Response to updated report and written response - 93 Washington Ave.

File: 17077 Response to City writeup:

Sheet
S1.1

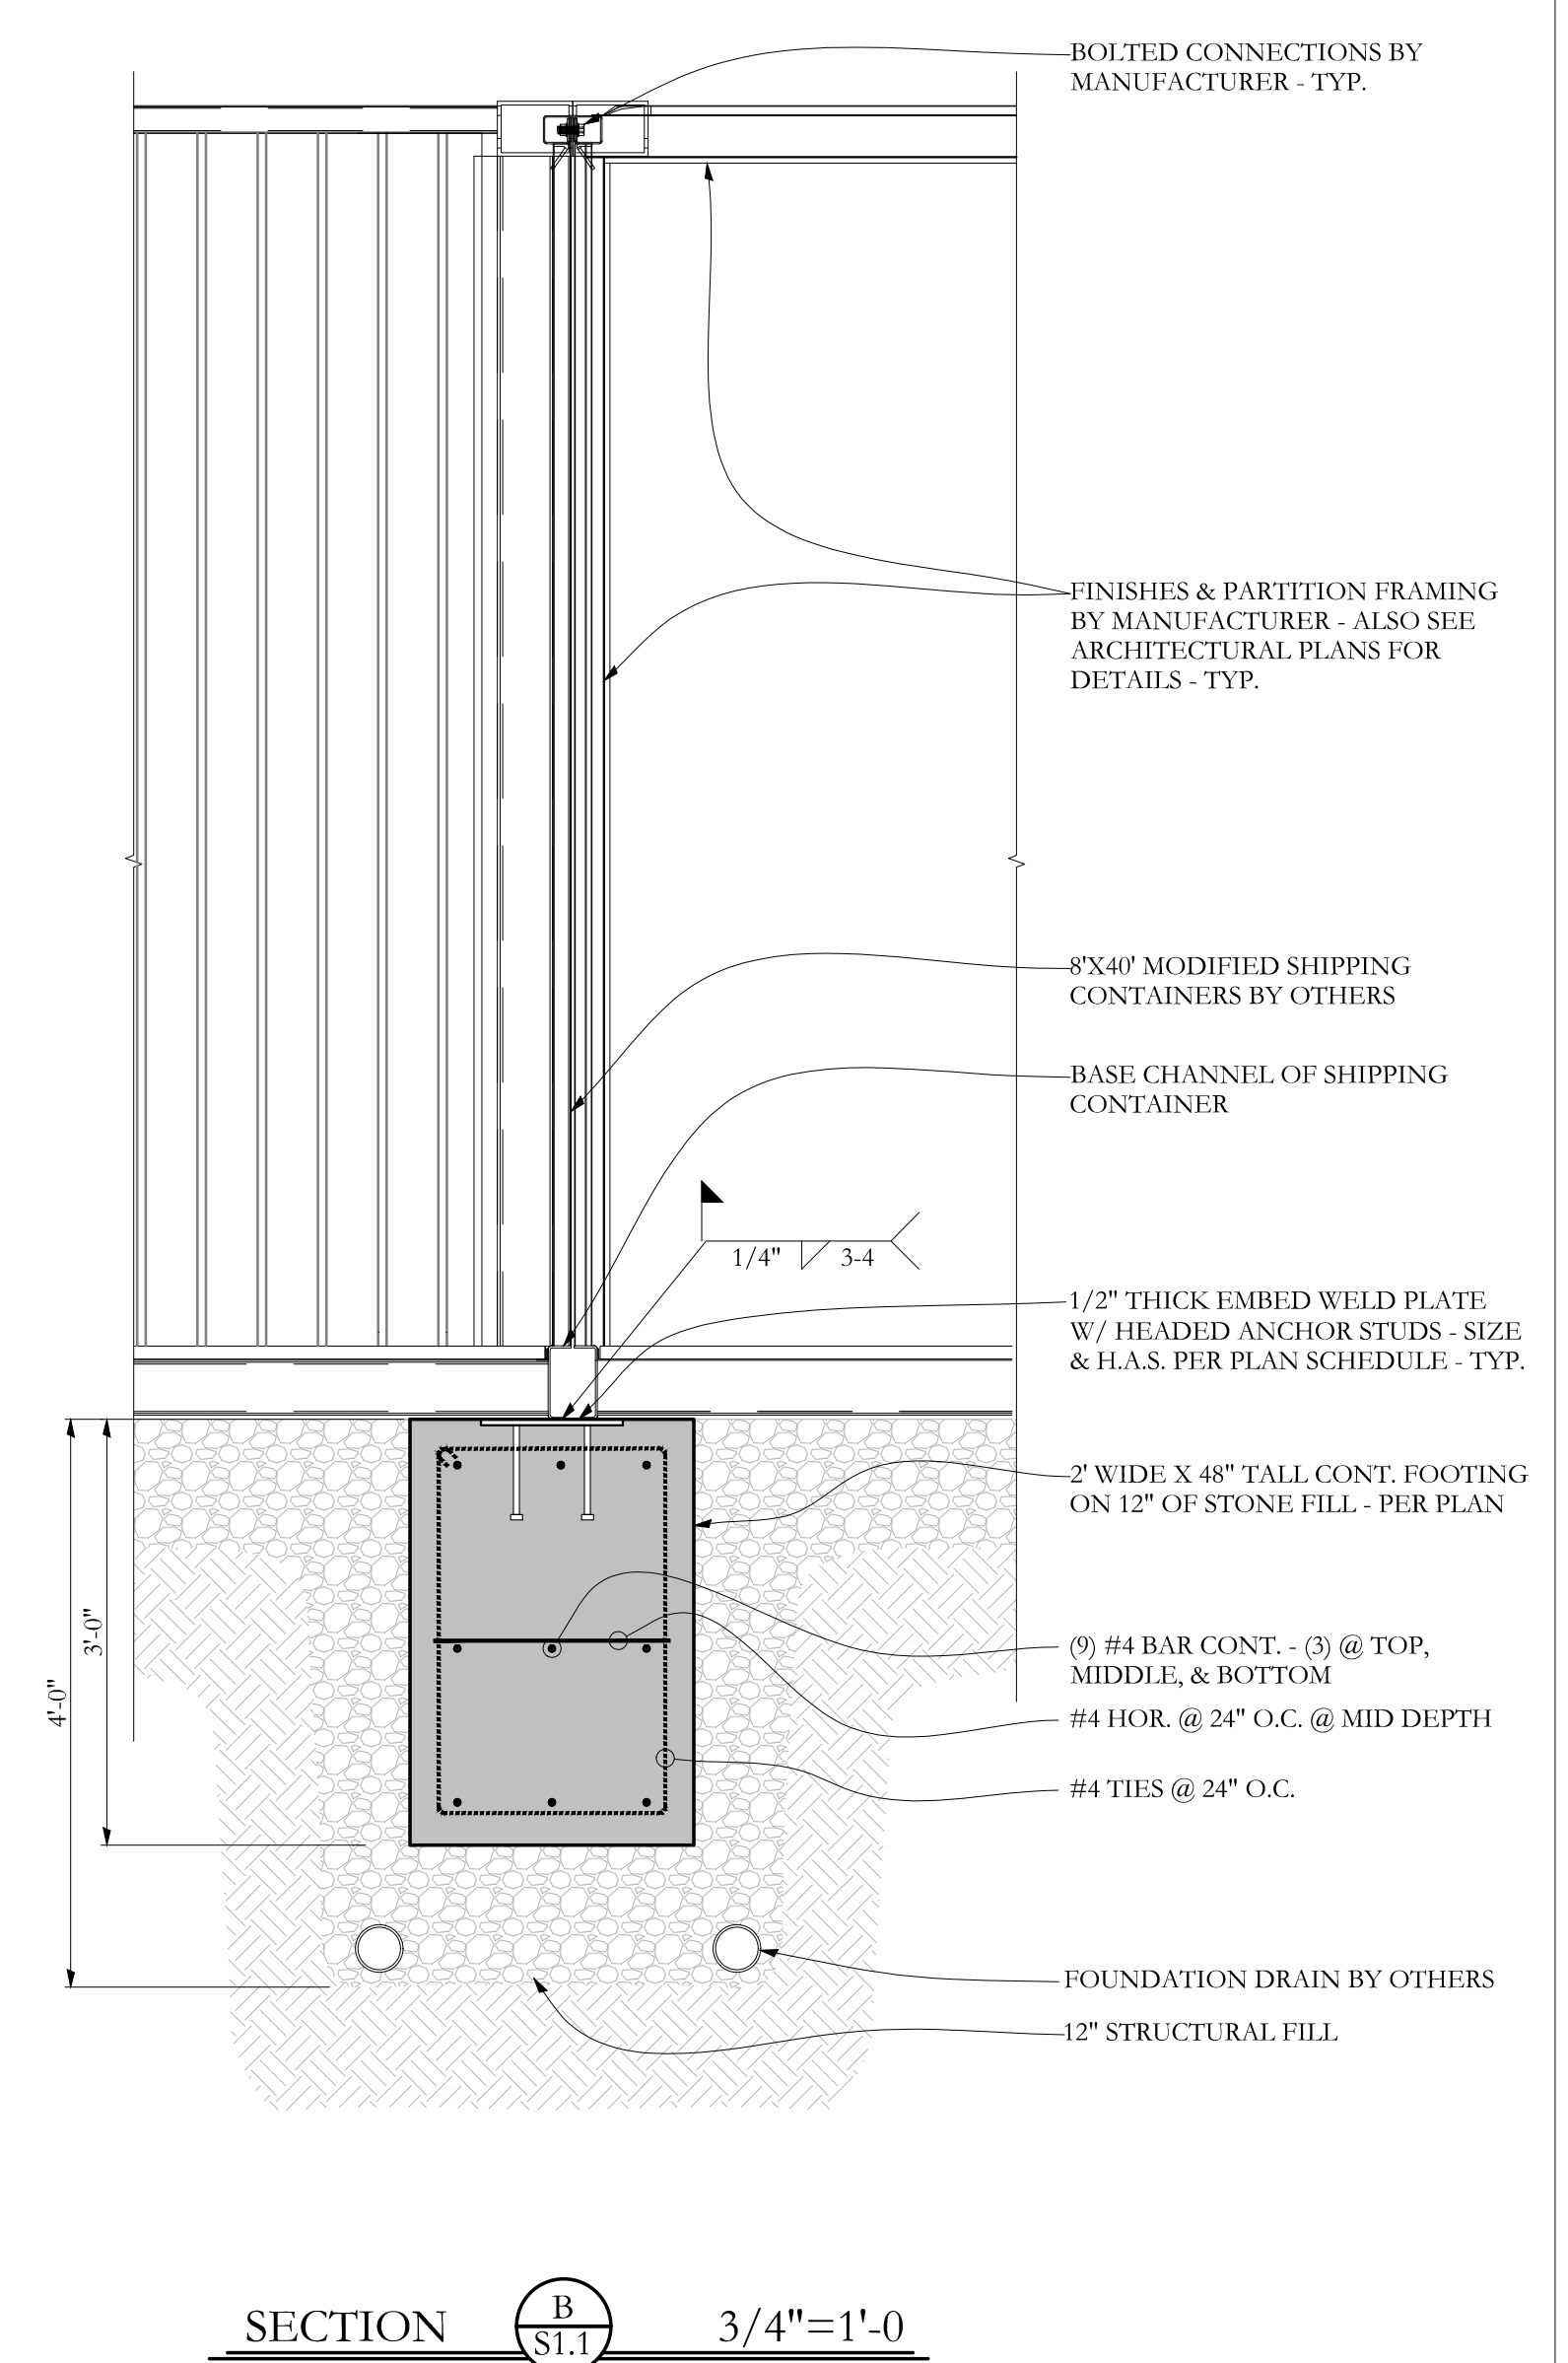
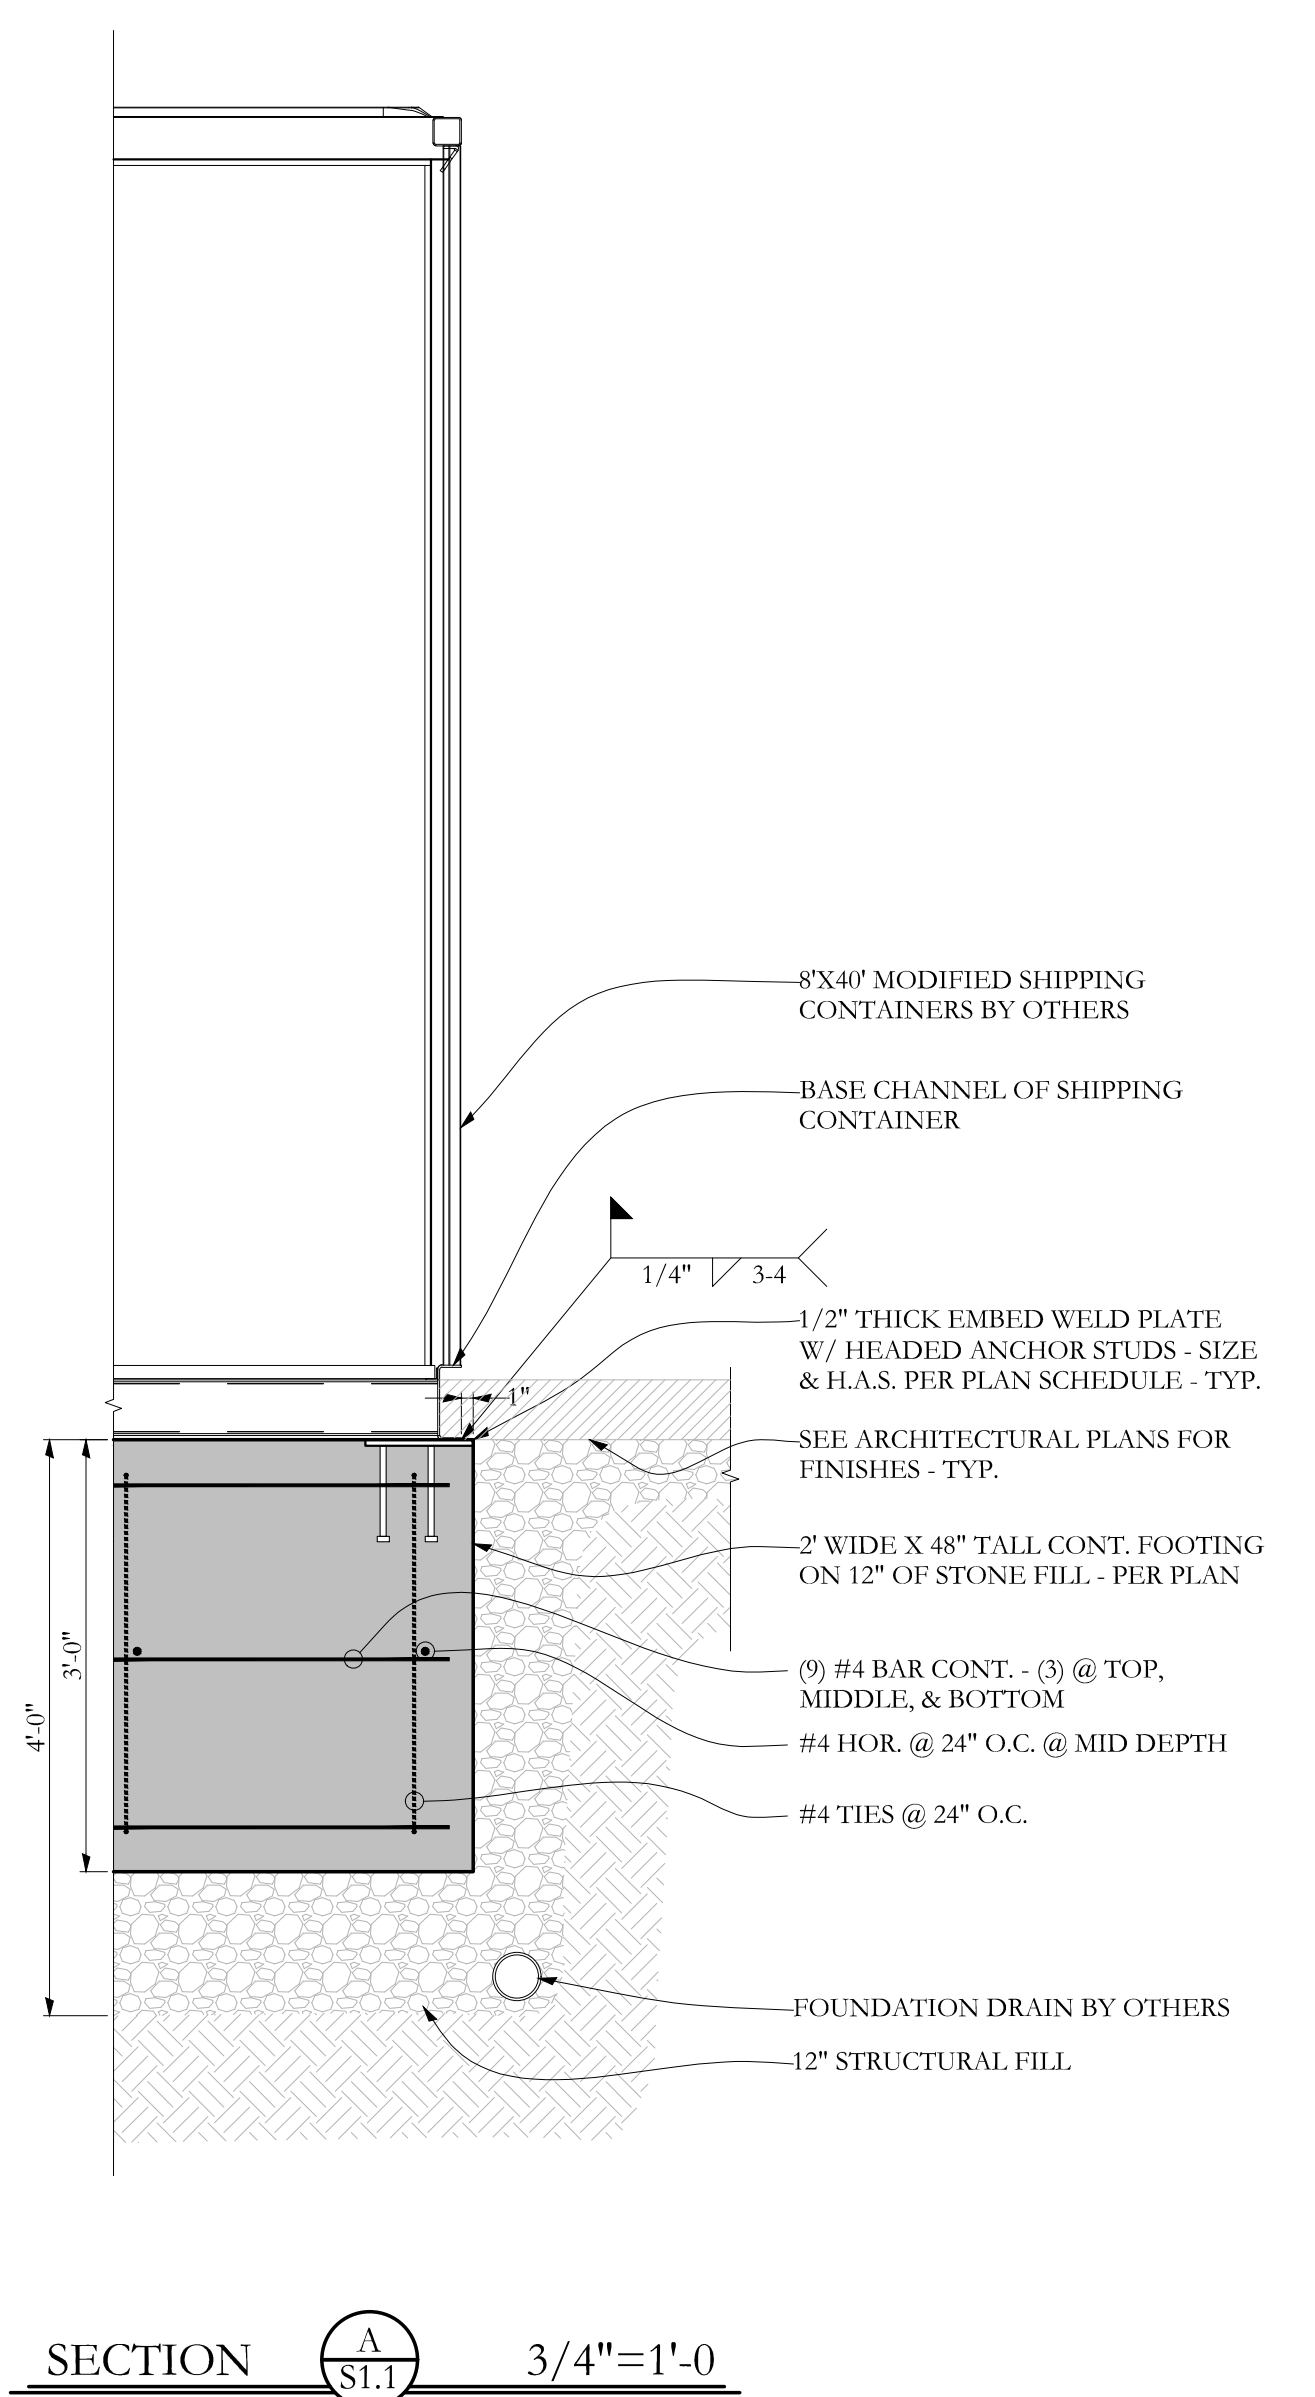
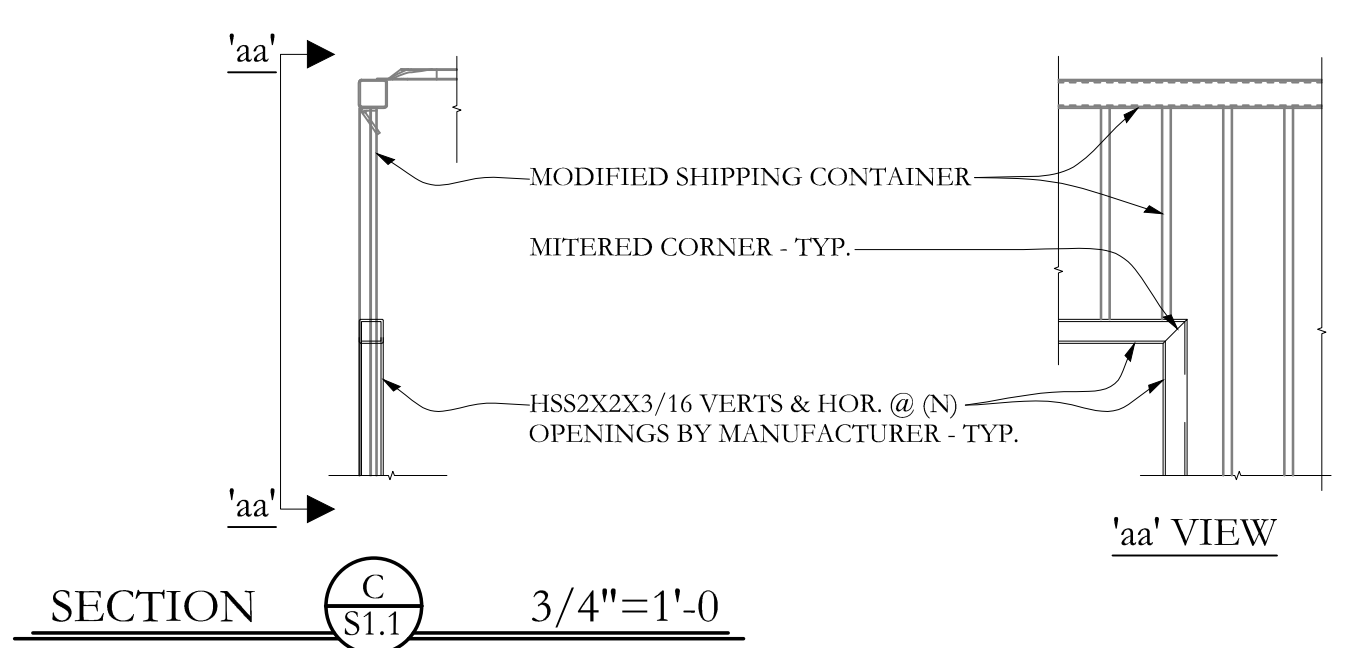
2. The letter from Keith dated 5/1/17 was preliminary to the development of the PID shipping container policy. My reply at the time, upon receipt from Jed Harris and Abigail Couture, was that the list of plans reviewed by Keith did not reference the structural, S-Plans. Please address this and follow up.
